## STAFF REPORT

### SUNCADIA PHASE 2 DIVISION 8 (LP-22-00005)

TO: Kittitas County Board of County Commissioners  
FROM: Kelly Bacon, Planner I  
RE: Suncadia Division Phase 2 Division 8 Preliminary Plat (LP-22-00005)  
DATE: January 3, 2023

SHEET:
PP-03
 3 OF 6 SHEETS

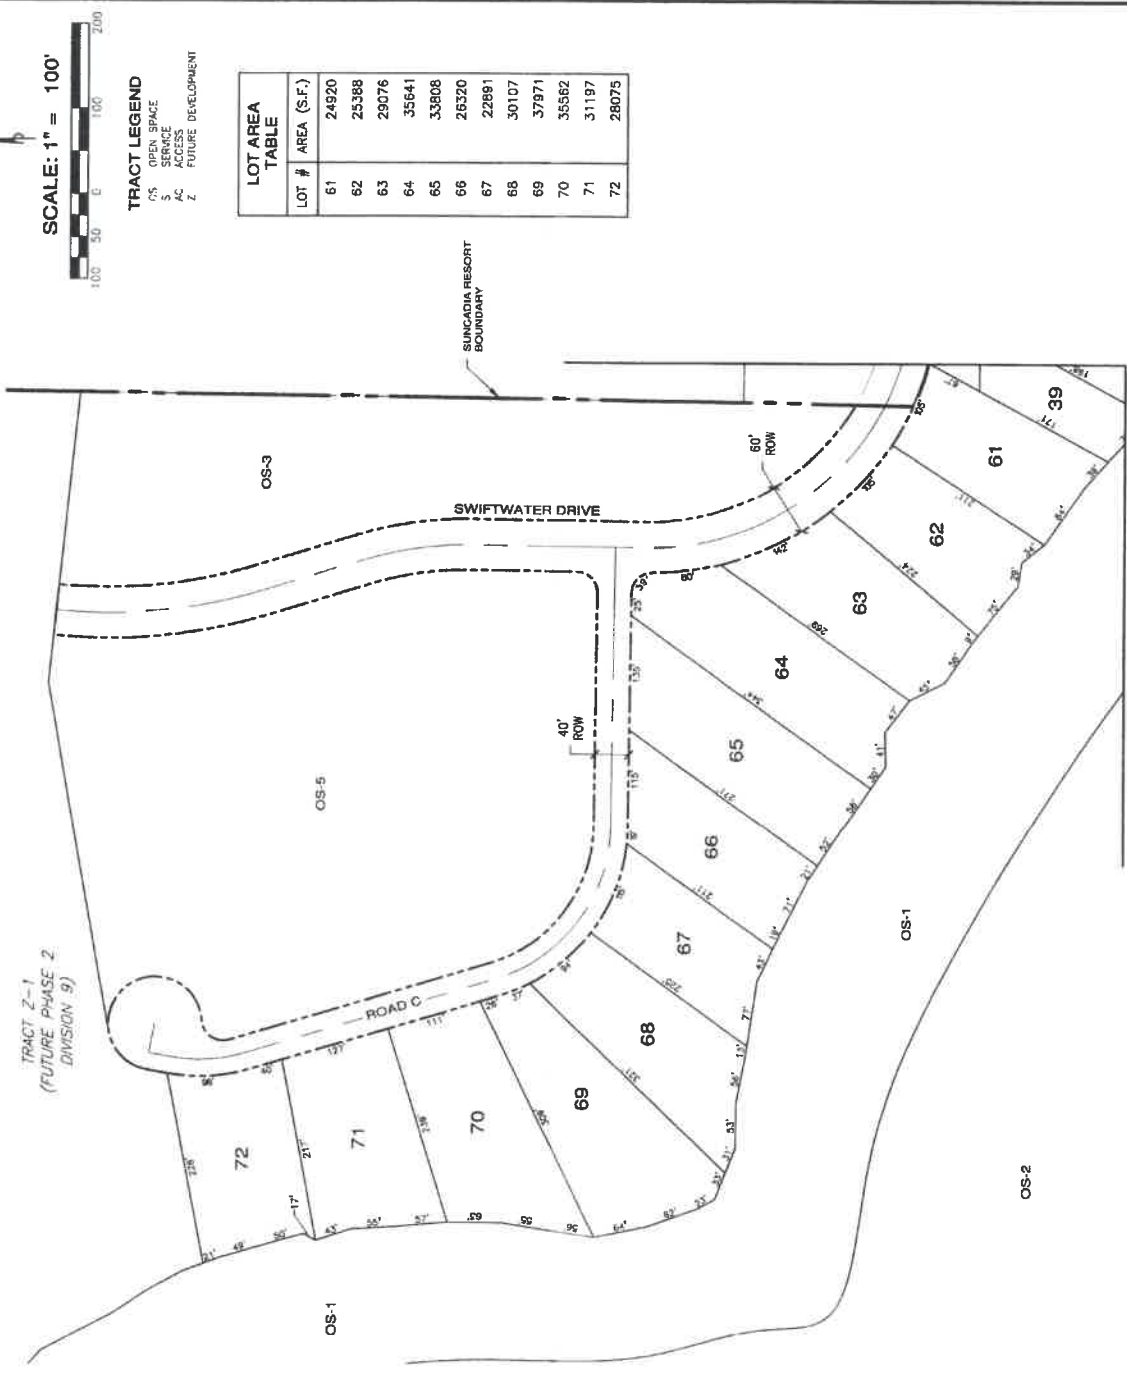
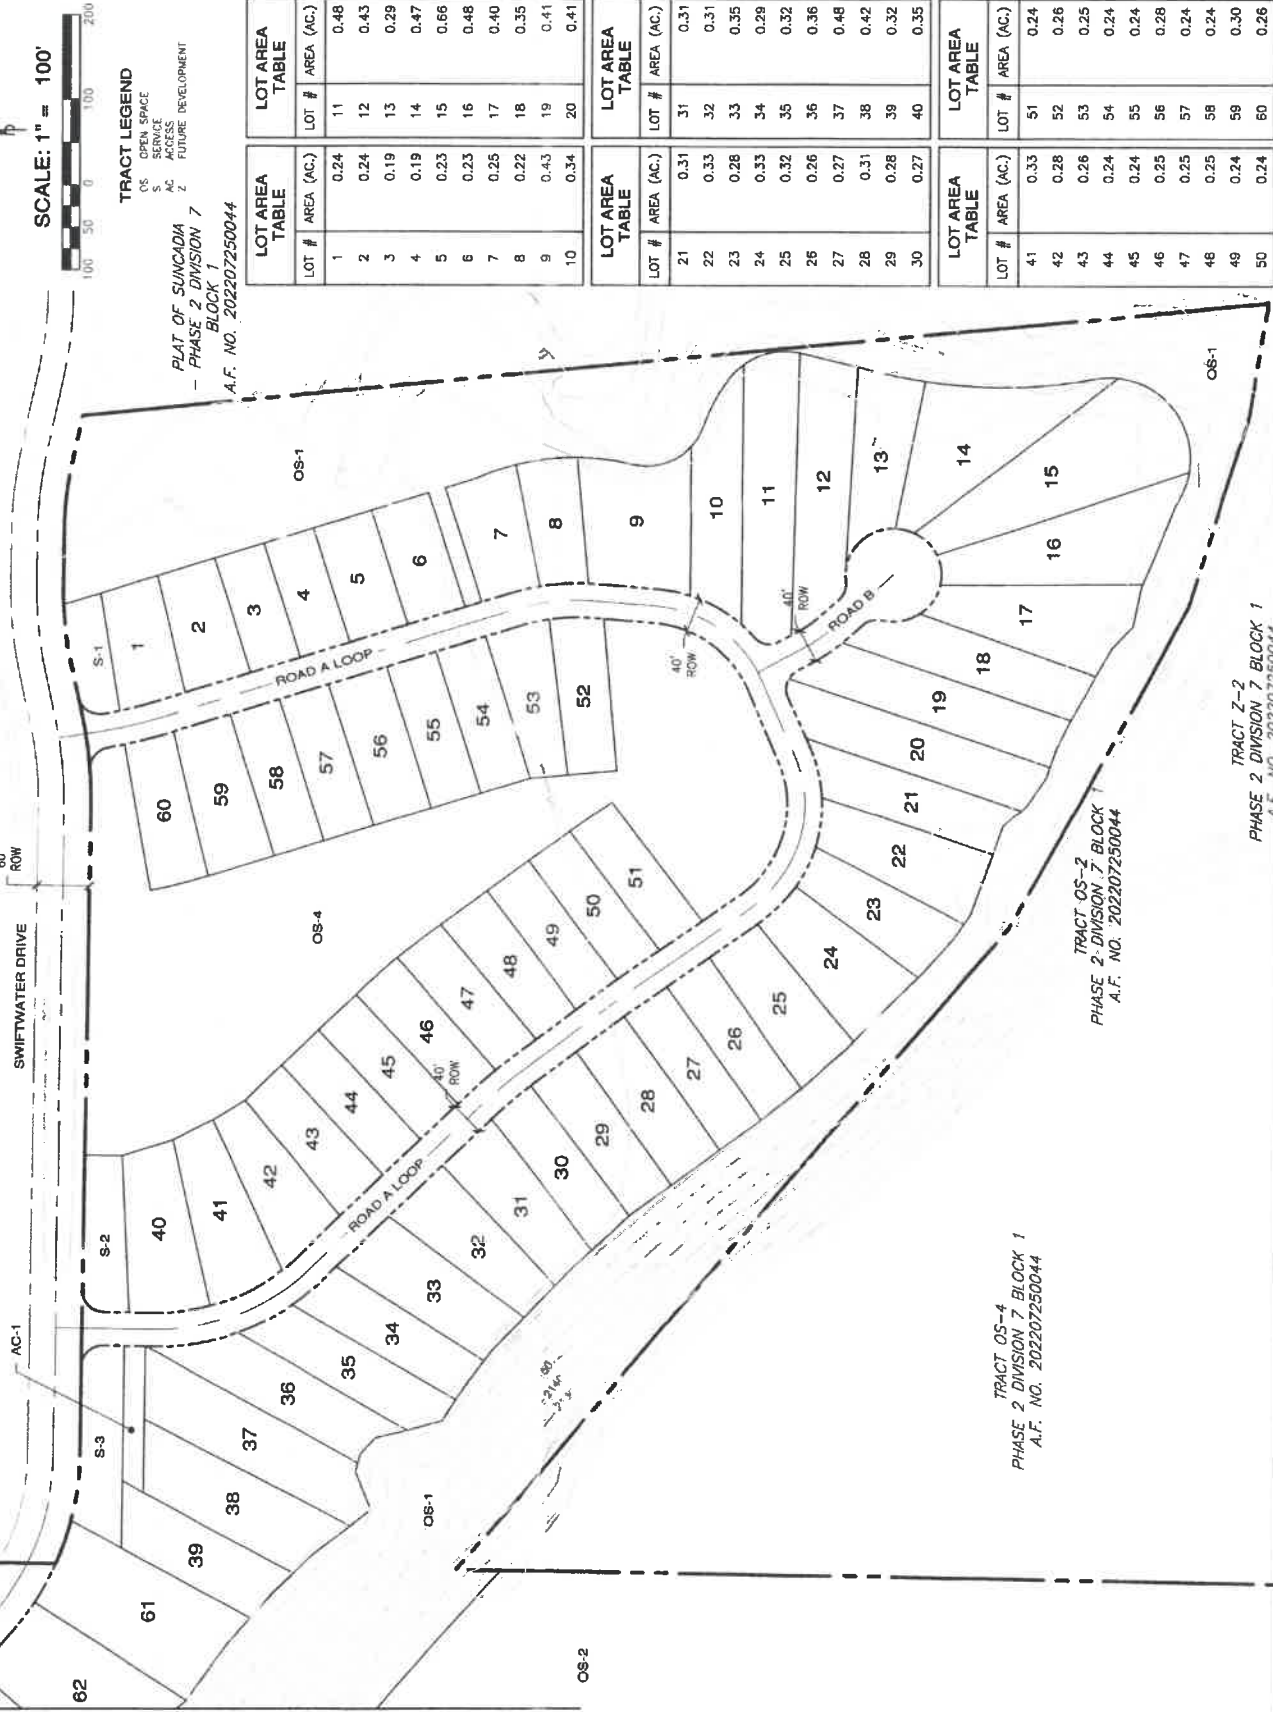
The Assessor's Office commented that Section 13 is not referred to at the top of the map with the other Section call outs and that Parcel 962679 is not reference.

Staff Response: The applicants corrected the two items brought forth by the Assessor's Office and are reflected in the amended preliminary plat drawings submitted 11-17-22.
